Application for a non-material amendment following a grant of planning permission.
 Town and Country Planning Act 1990

Erection of two storey rear extension and two storey side extension.

21/02734/HS.

to alter first floor bedroom arrangements and ground floor entrance

NMA - proposed - layouts

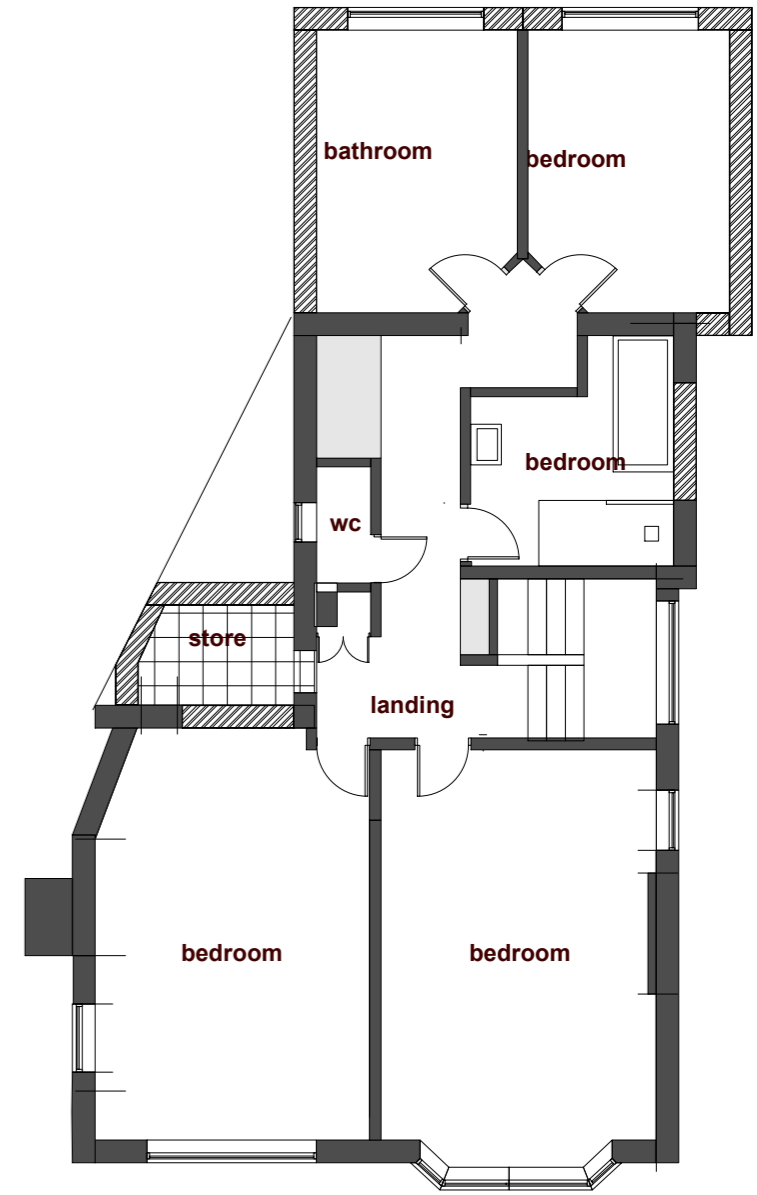
to provide additional bedroom for carer and better wheelchair access to front entrance
